Mark Brown - Re: MP 08_0104 MOD 4 - Modification to Approved College of Fine Arts

Subject MP 08_0104 MOD 4 - Modification to Approved College of Fine Arts

The Department has received a modification request, as attached, for deletion of Condition No. 49 - Electricity Submission of the above project.

**Figure 3** – Approved plan illustrating location of substation along Greens Road frontage

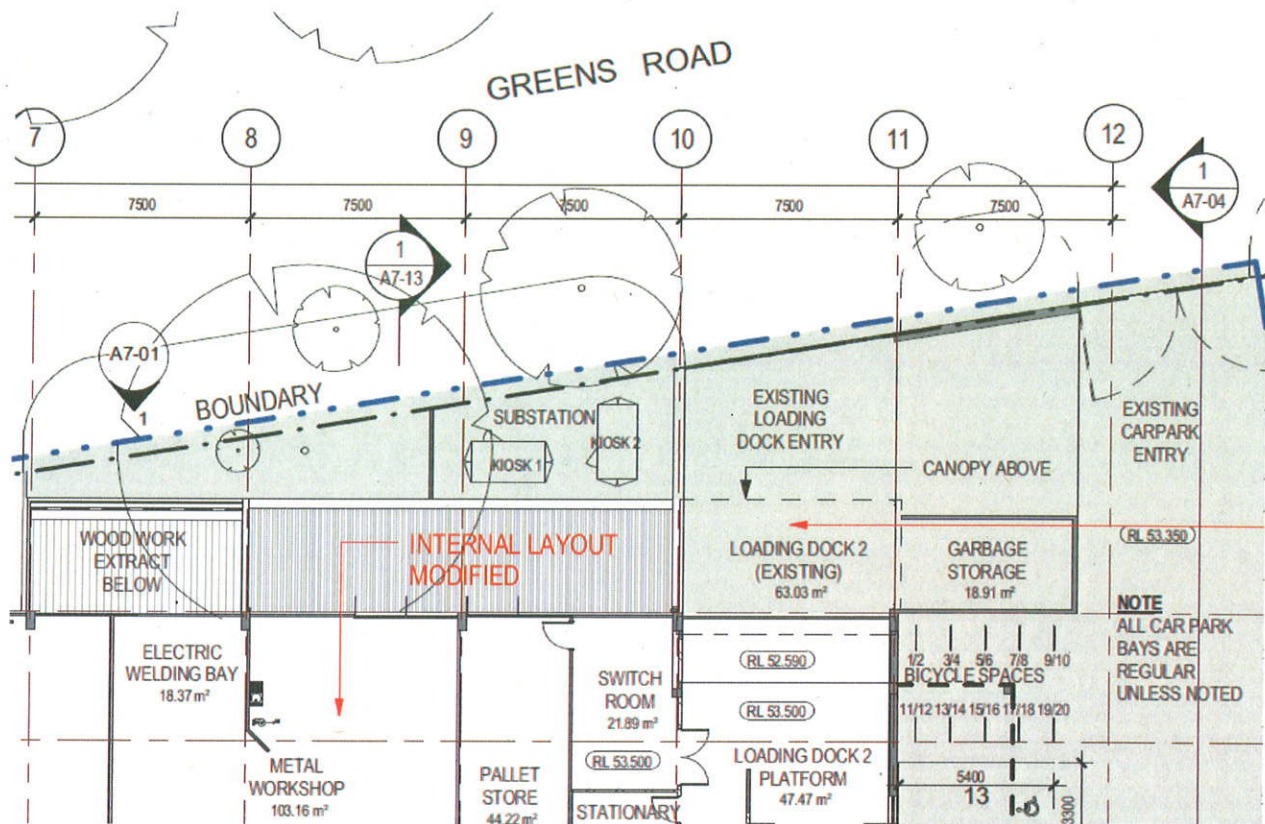
It is advised that Ausgrid is in agreement with the location of the substations, it aligns with the preferred site selection for kiosk substations (NS141).

Ausgrid did not agree to ensure that there would be no impact on the adjacent gum, however:

The ASP3 conducted an Environmental Impact Assessment (EIA), which included the impact this project would have on the surrounding Flora.

Ausgrid's Environmental Services Unit was satisfied with the assessment, and so verified the EIA.

The final certified design showed that specific measures were taken to specifically minimise the impact on the trees around the substation.

1. Minor adjustment to the substation final location o avoid tree roots and root exclusion zone.
2. Root barrier installed along the perimeter of the substation easement near to the trees.
